CITY OF ALBUQUERQUE

May 3, 2023

Re: Bruner Metal Building
4012 2nd St. NW
Traffic Circulation Layout
Architect's Stamp 08-09-22 (G14-D101)

TRAFFIC CIRCULATION LAYOUT

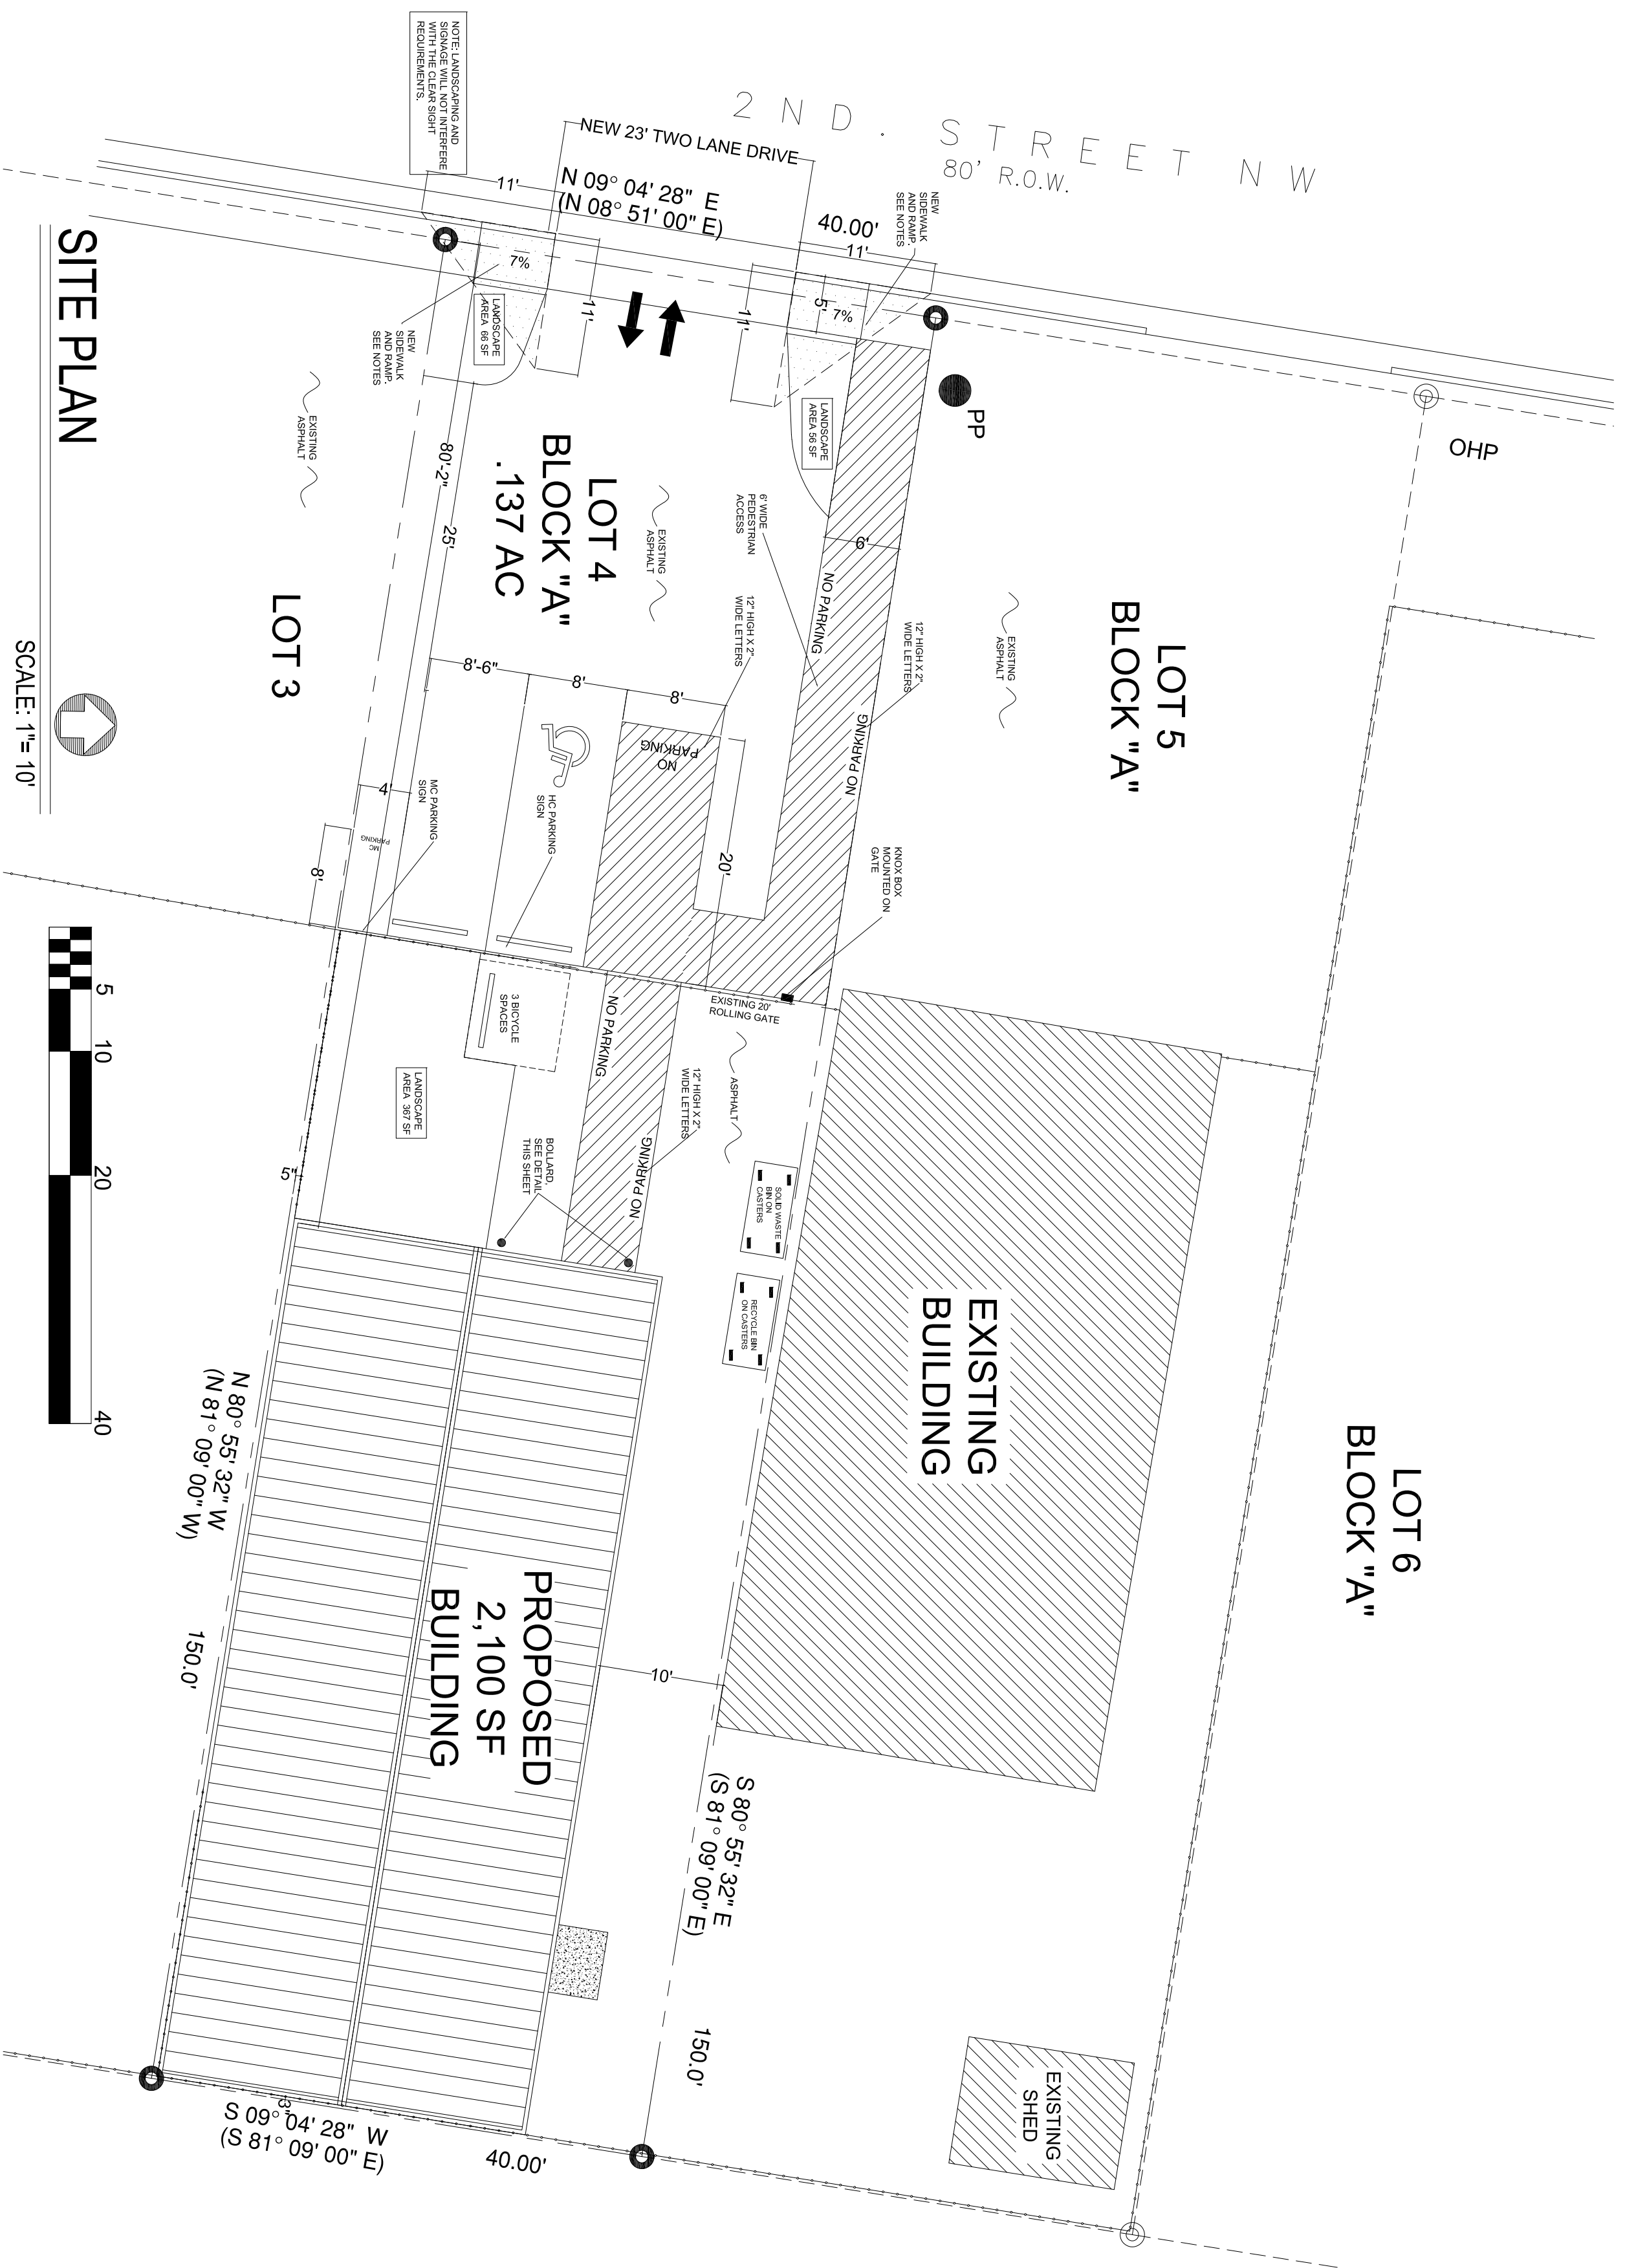
1. List the number of Bicycle and Motorcycle parking spaces required by the IDO.
2. Identify all existing access easements and rights of way width dimensions.
3. Please update the site to the current ADA standard and reference city standard drawing.
4. Sidewalk must be built in front of the site from property line to property line. For sidewalk waviness, please contact Ernest Armijo at (505)-924-3991 earmijo@cabq.gov
5. Is the existing site access used by lot 5 and lot 3? If so, please provide shared access agreement.
6. Maximum access width for arterial, collector, and local streets are as follows:

7. Please note that 2nd St. is classified as Principal Arterial.
8. Motorcycle parking spaces shall be designated by its own conspicuously posted upright sign, either free-standing or wall mounted per the zoning code.
9. The pavement marking "MC" should be shown in the opposite direction for Motorcycles entering the parking space.
10. All bicycle racks shall be designed according to the following guidelines:
 - a. The rack shall be a minimum 30 inches tall and 18 inches wide.

11. Bicycle racks shall be sturdy and anchored to a concrete pad.
12. A 1-foot clear zone around the bicycle parking stall shall be provided.
13. Bicycle parking spaces shall be at least 6 feet long and 2 feet wide.

14. Per the IDO, a 6 ft. wide ADA accessible pedestrian pathway is required from the public sidewalk to the building entrances. Please clearly show this pathway and provide details.

15. Per DPM, a 6 ft. wide ADA accessible pedestrian pathway is required from the ADA parking stall access aisles to the building entrances. Please clearly show this pathway and provide details.

16. ADA accessible pedestrian pathway should not be placed behind parking space or adjacent to a vehicular way. Vehicle and pedestrian/wheel chair conflicts should be avoided as much as possible.

17. Parking areas shall have barriers to prevent vehicles from extending over public sidewalk, public right-of-way, or abutting lots.
18. Refuse vehicle maneuvering shall be contained on-site. The refuse vehicle shall not back into the public right of way.; provide a copy of refuse approval.

19. Please provide a copy of Fire Marshal approval.
20. Show the clear sight triangle and add the following note to the plan: "Landscaping and signage will not interfere with clear sight requirements. Therefore, signs, walls, trees, and shrubbery between 3 and 8 feet tall (as measured from the gutter pan) will not be acceptable in the clear sight triangle.

23. Please add a note on the plan stating "All improvements located in the Right of Way must be included on the work order."
24. Unused curb cuts must be replaced with sidewalk and curb & gutter. A build note must be provided referring to the appropriate City Standard drawing.
